**RE: Grading and Drainage Plan for Spec Residence, Lot 20, Block 3, Tract 3, Unit 3,
NAA, (C20/D19) Engineer's Stamp Dated 2/28/98.**

Susan M. Calongne, P.E.
City/County Floodplain Administrator

project title	LT CONSTRUCTION CORP. RICHFIELD AVE. NE ALBUQUERQUE, NM		
sheet title	GRADING & DRAINAGE PLAN		
sheet date	design by	project no.	
02/26/98	JJB	9804	
		sheet	of

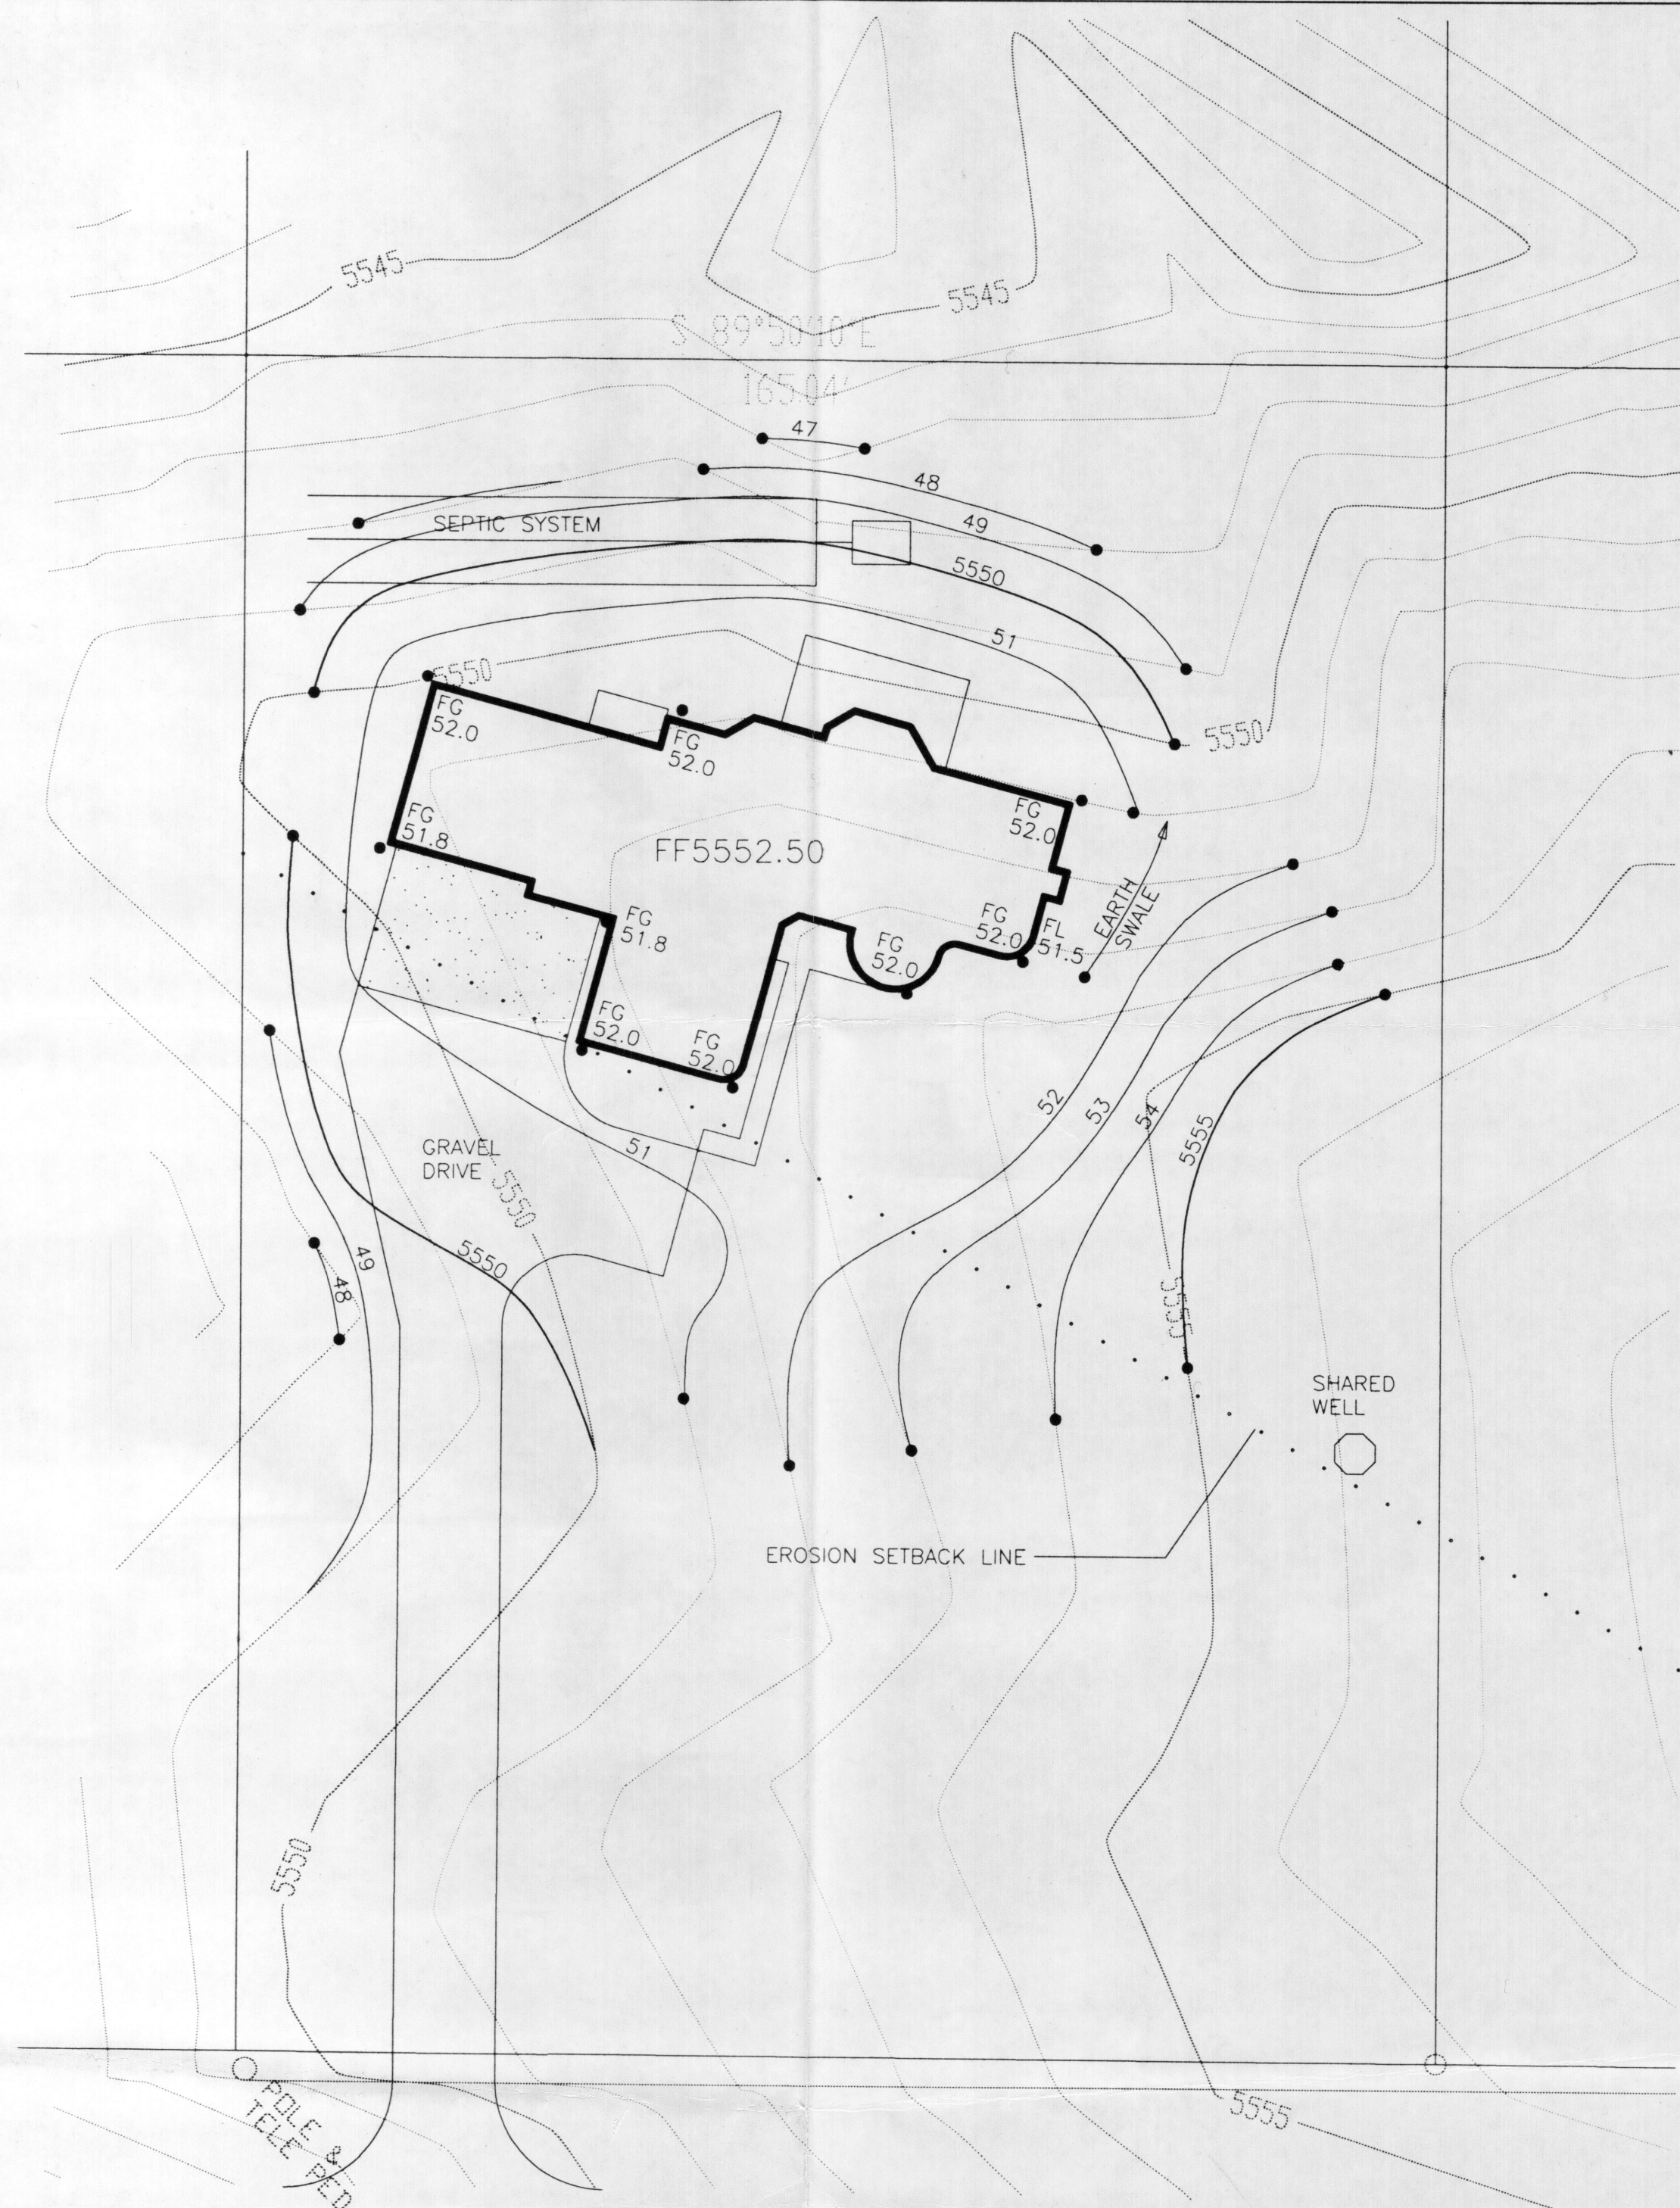
The above referenced property is not located within a special flood hazard area as defined by FEMA. The plan shows that the proposed residence is located beyond the erosion setback limit therefore, this plan is acceptable for Building Permit release. The owners should be made aware that a large portion of the front of this Lot may be subject to erosion.
